BP #2015-02465 - 131 Washington Ave

Construction is well under way at the 131 Washington Ave project. The owner has been showing the renovated building to prospective tenants and there has been a nearly universal request to reconfigure the stair from the Second Floor down to the Common Room in order to maximize extremely limited usable space within the ell.

Sheet No: **A-1**

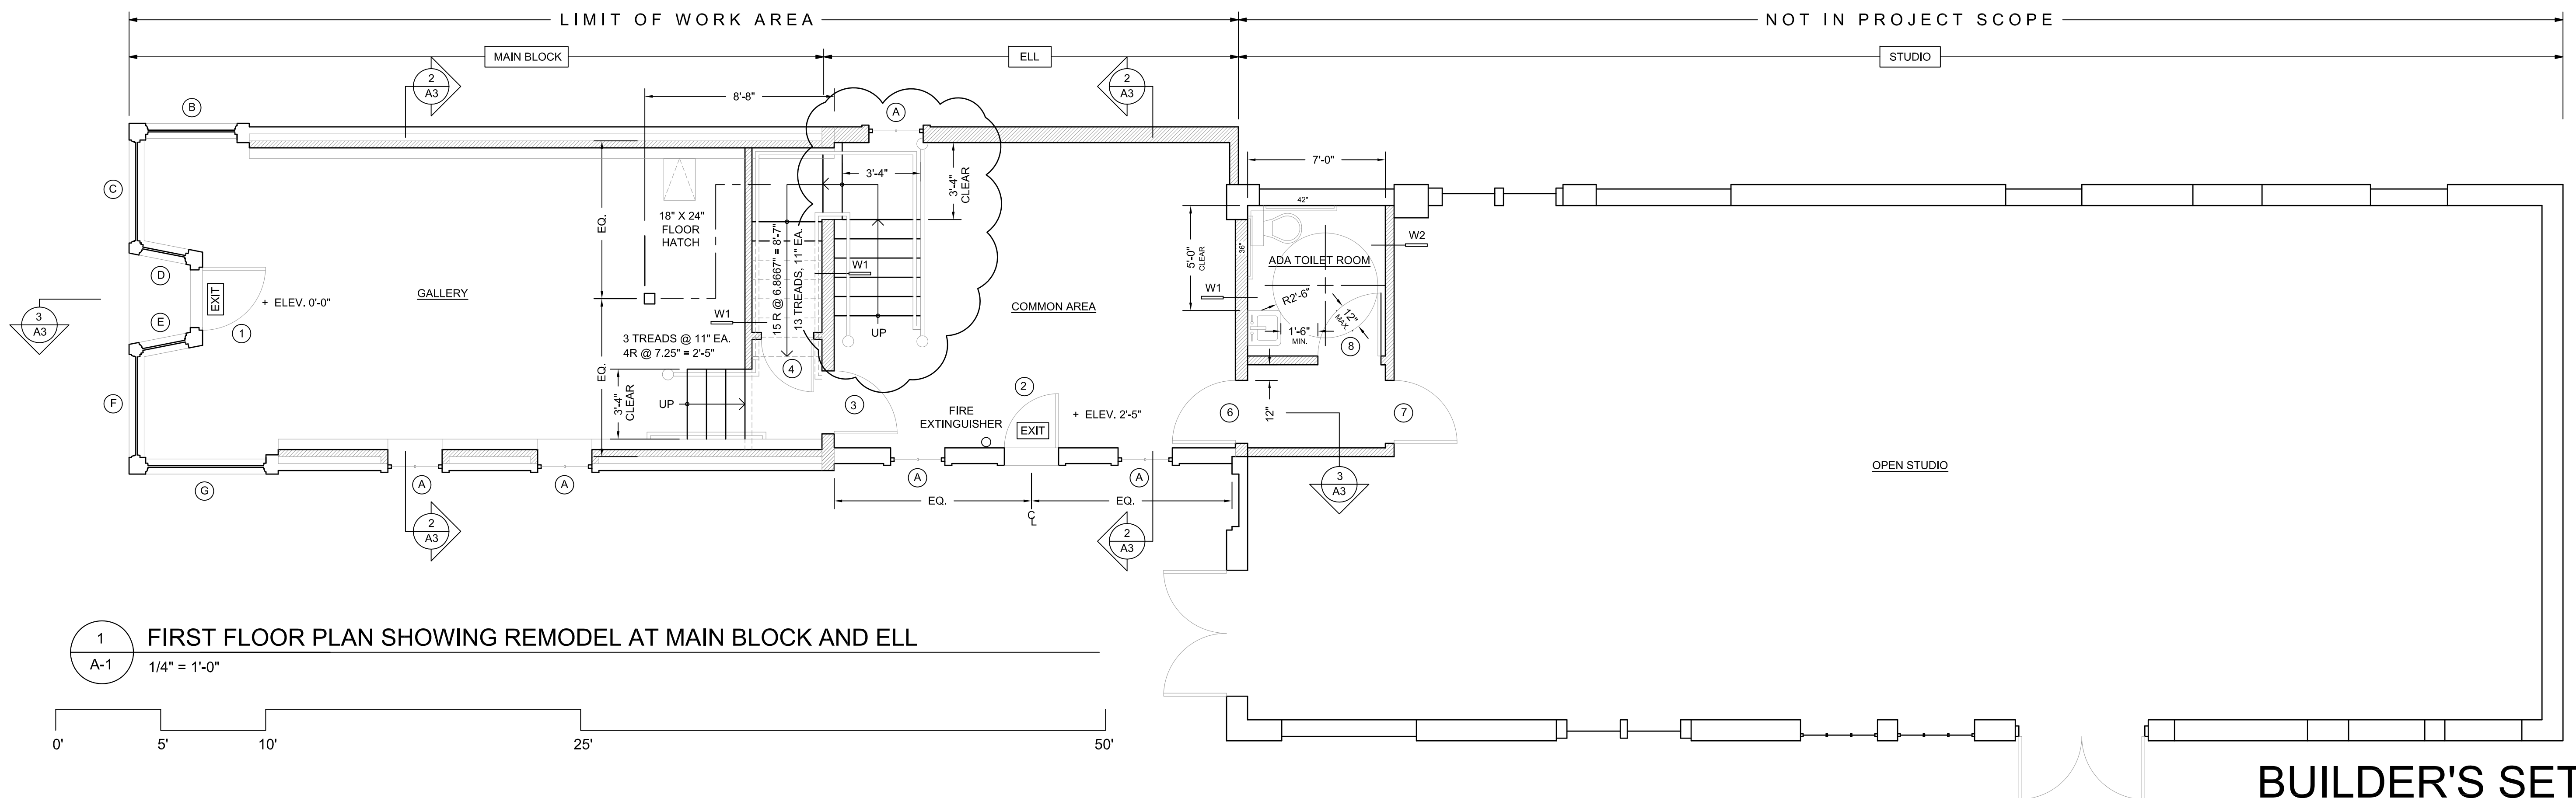
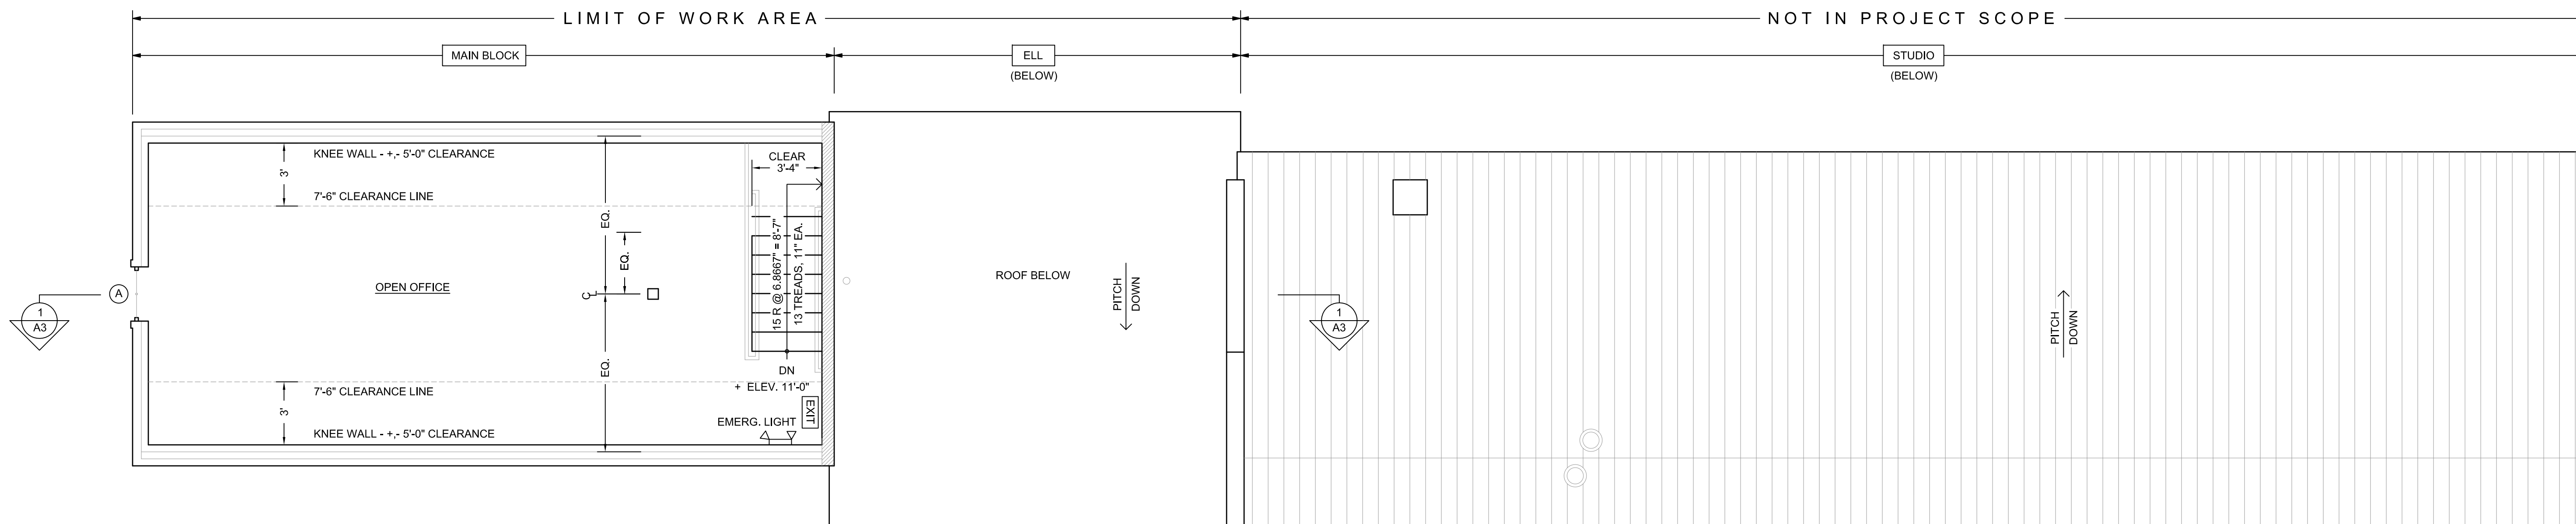
Attached is a revised drawing showing this change. Please let me know if you have any concerns or comments and if any additional information is needed.
